8 June 2011

M5 West Widening Project- Submission on the Preferred Project Report

Attachment A

Issues and Concerns

May 2011

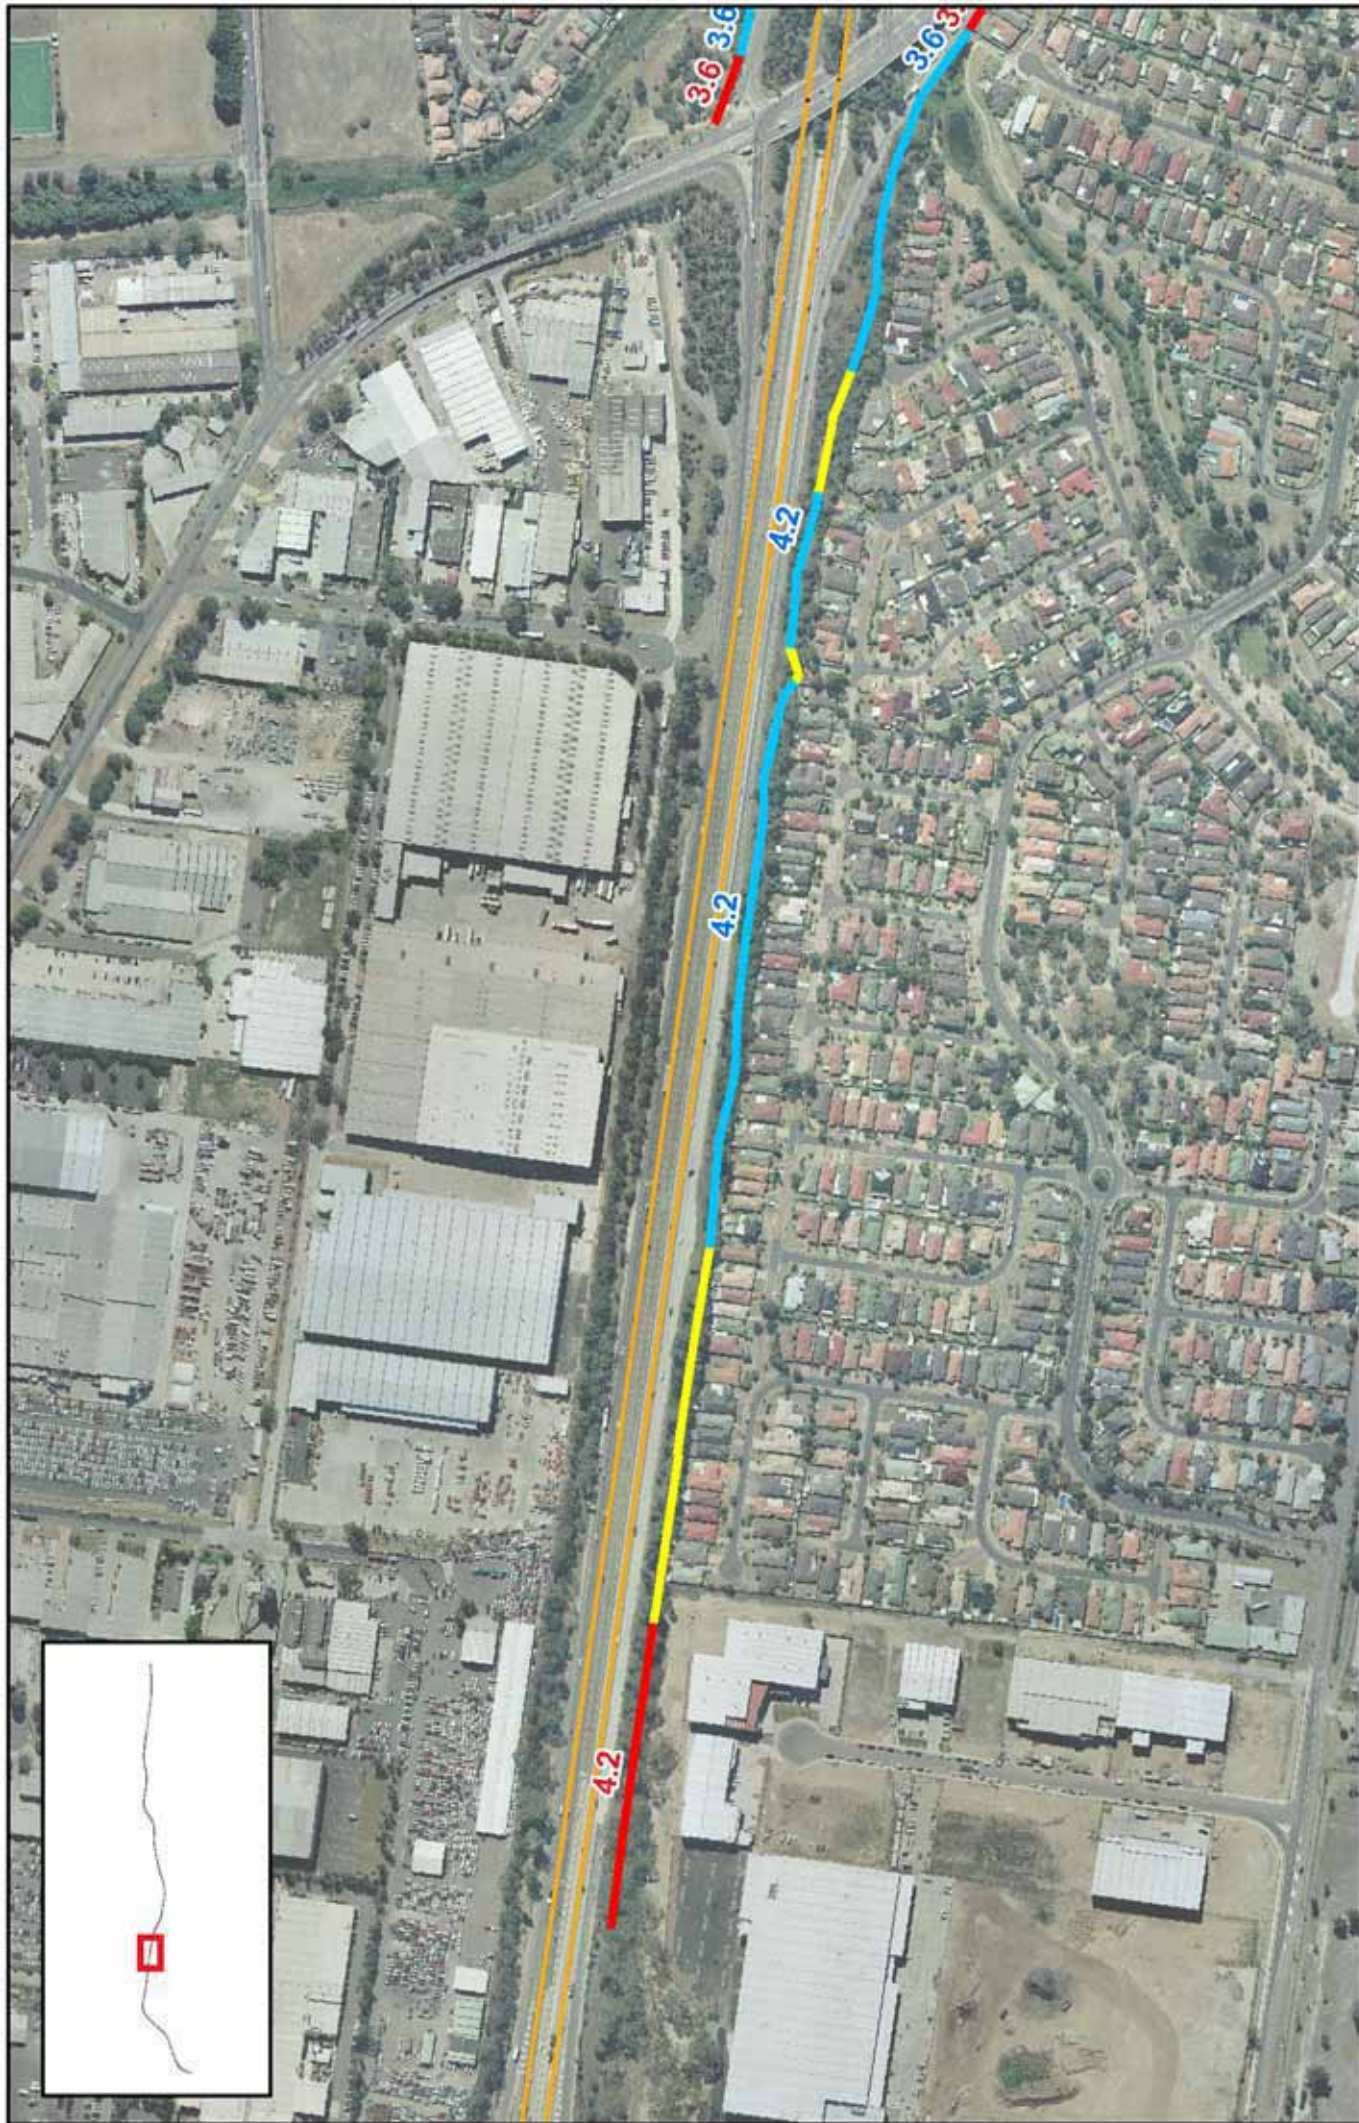
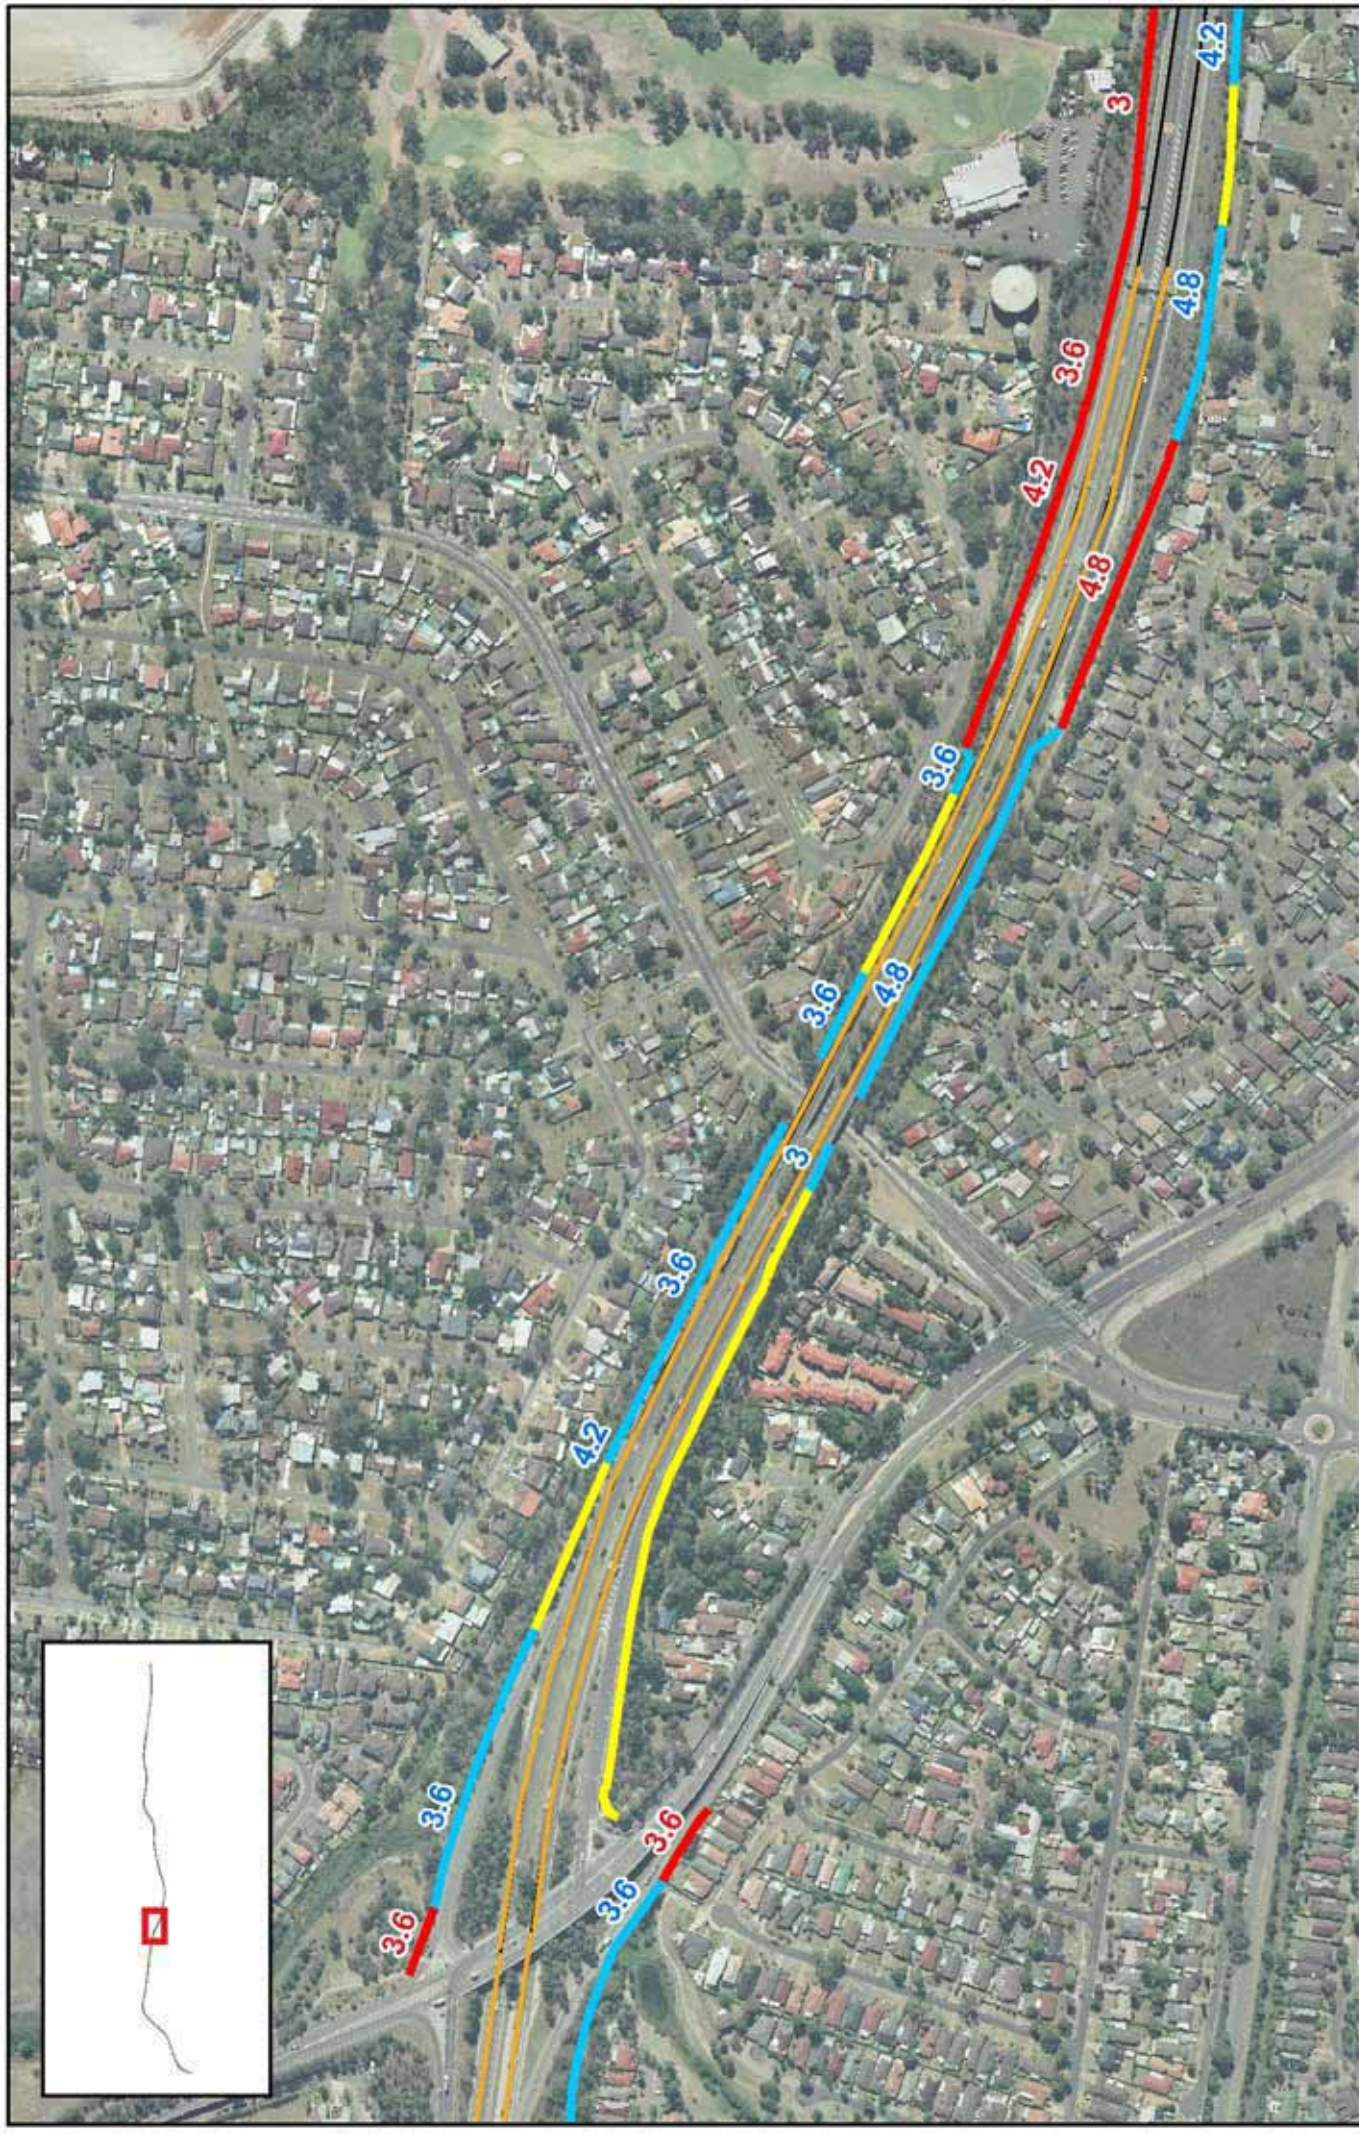
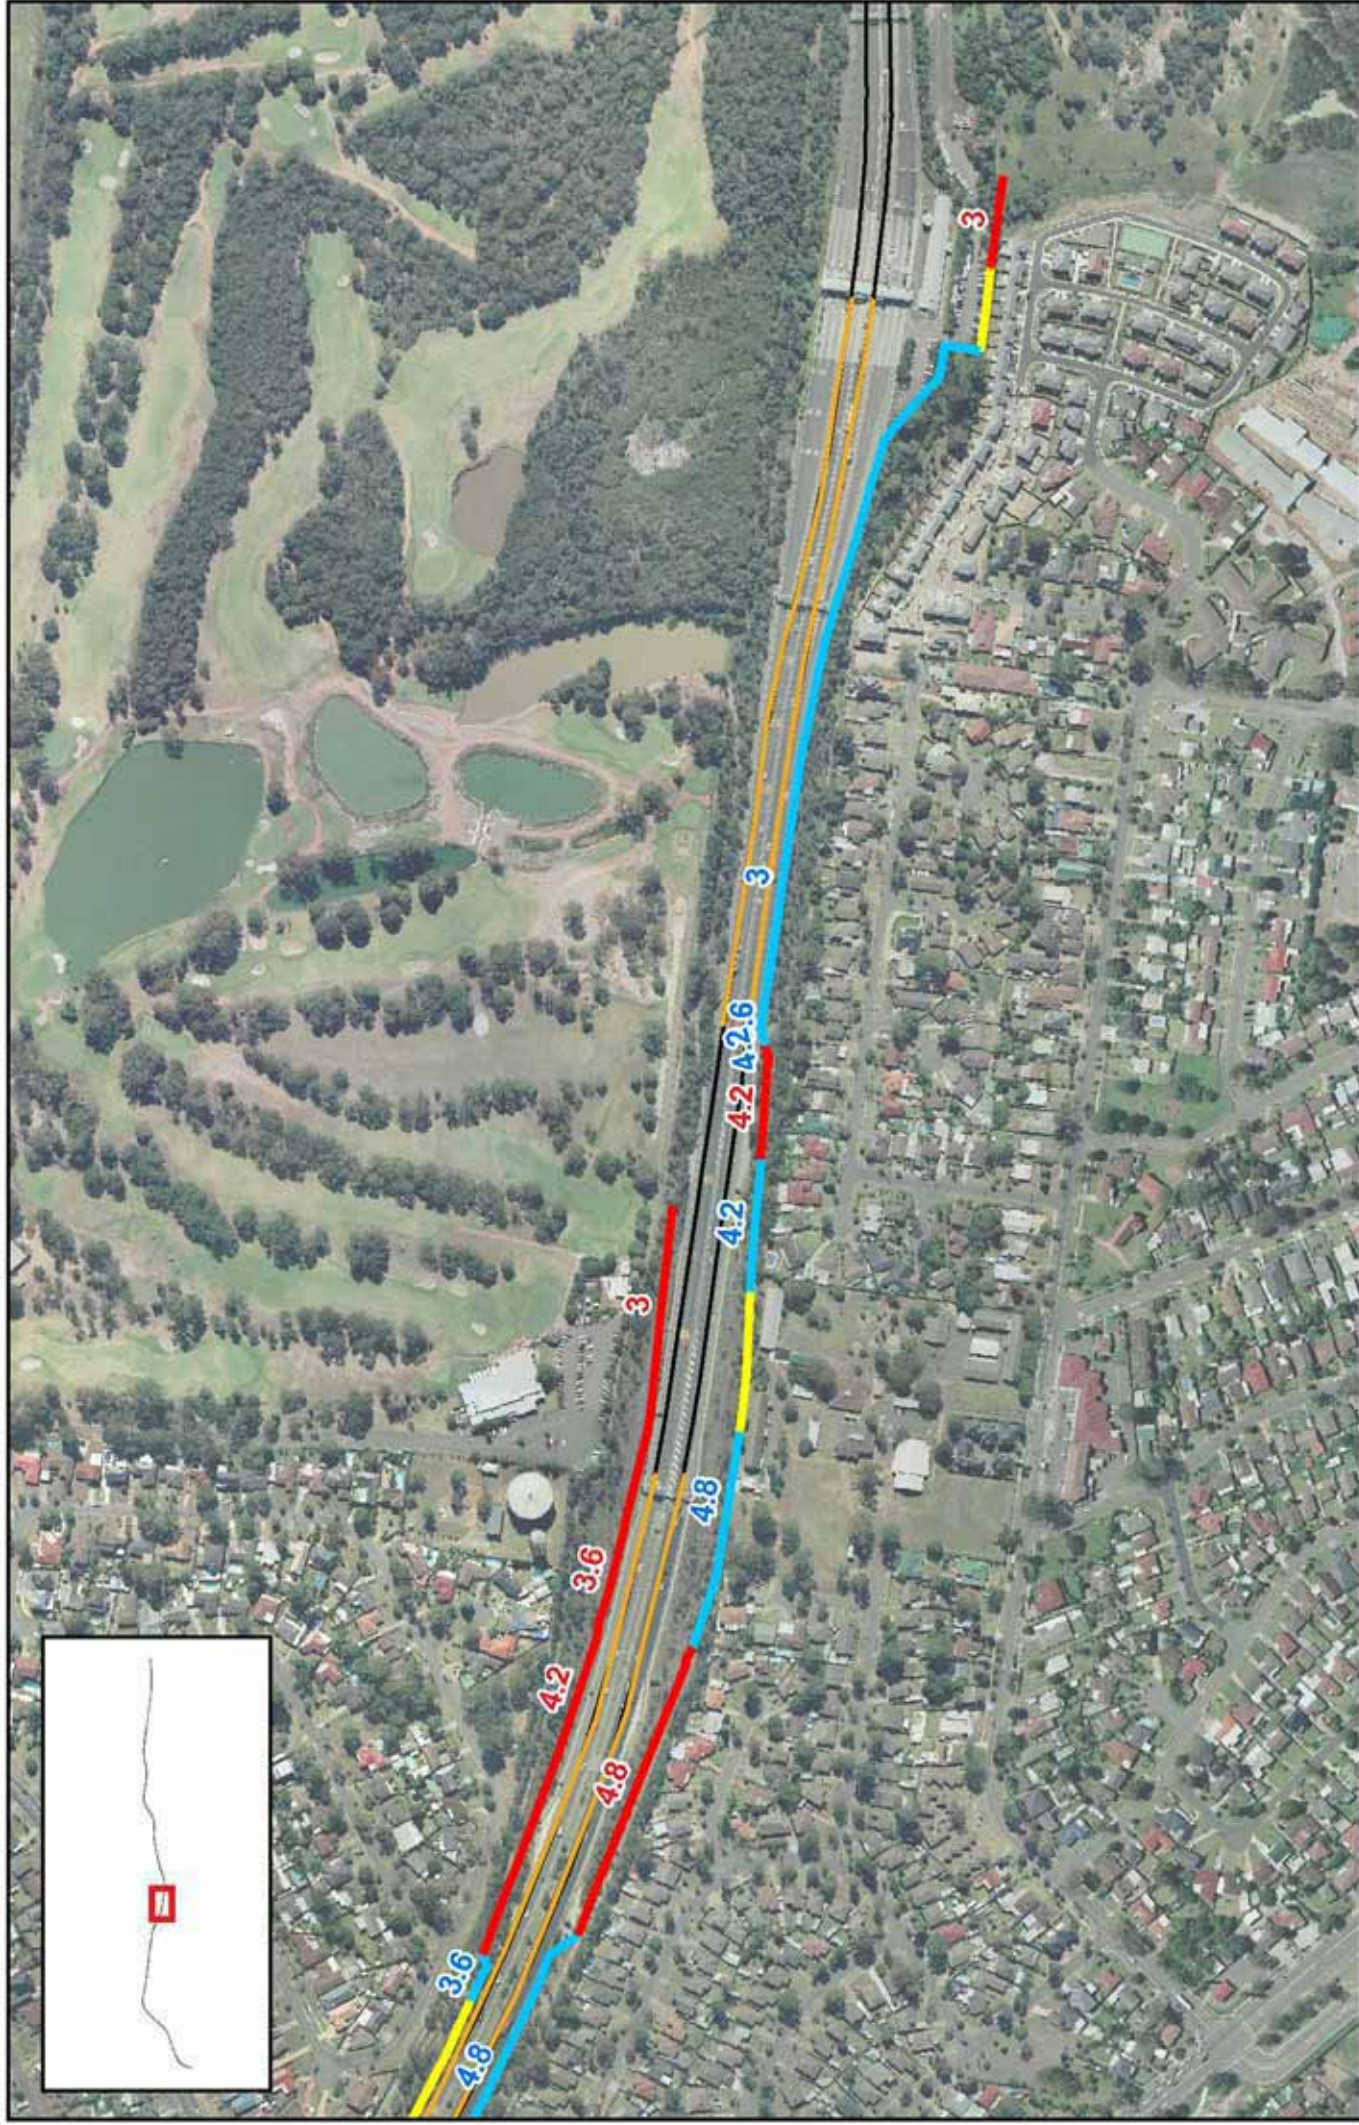
Council is concerned that the new changes to the noise barriers and installation of architectural treatments will have a negative impact on the amenity of the residents, such as limiting solar access into a dwelling and glare problems during the night which have not been discussed in the Environmental Assessment and/or the Preferred Project Report.

The Preferred Project Report currently does not specify noise mitigation details for reducing noise impacts on sensitive land uses where noise criteria are exceeded.

The 'Revised Statement of Commitments' must include the following statement: "Bankstown City Council and all affected properties within the study area will be consulted prior to the commencement of the project to discuss and develop an Operational Noise Management Plan to mitigate the noise impacts."
